Application No: AB/74/21/L
Site Address: 11 Bond Street Arundel BN18 9BL
Description of works: Listed building consent for the installation of conservation velux rooflight to rear outbuilding.

Thank you for your internet representation made on 23rd July 2021 which has been recorded as no objection with the comments as follows:

PROPOSED ELEVATIONS AND FLOOR
PLAN

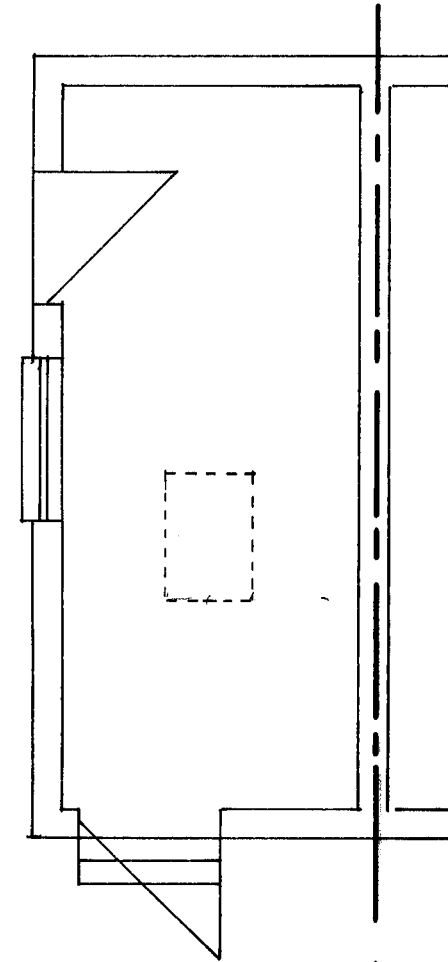
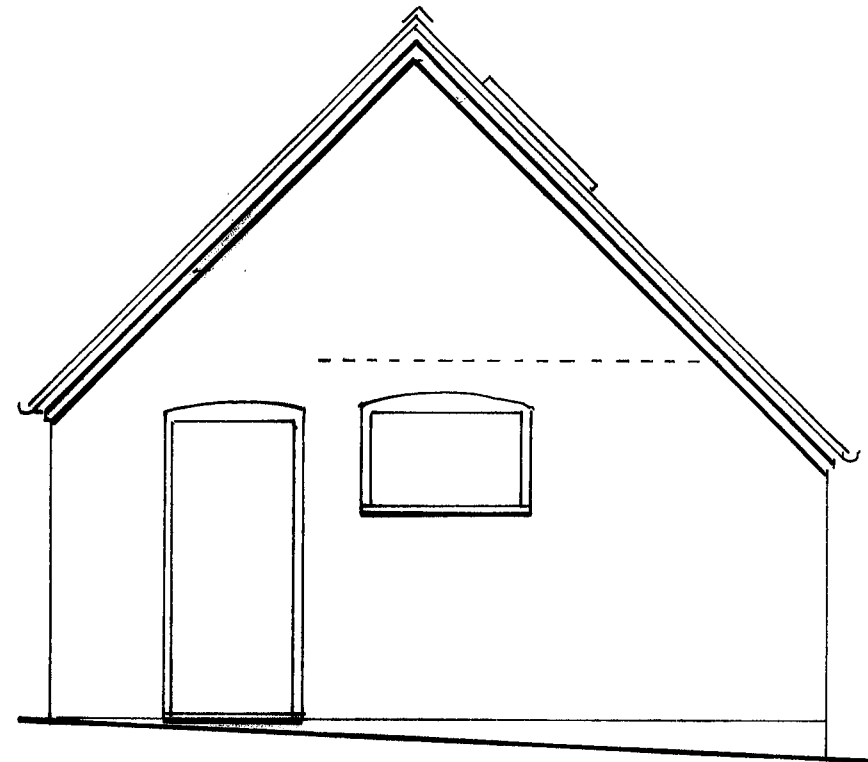
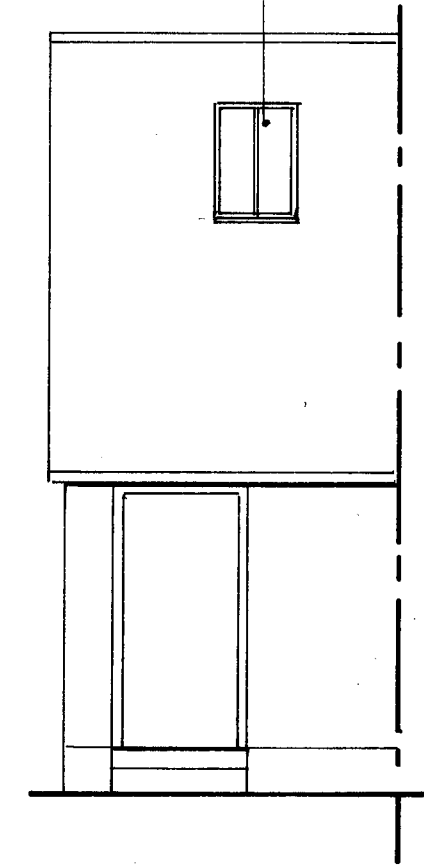
The proposed conservation roof light is of an appropriate size and location on the roof slope of a late 19th Century outbuilding at the rear of the property.
There will be no adverse impact on the character or appearance of the conservation area.
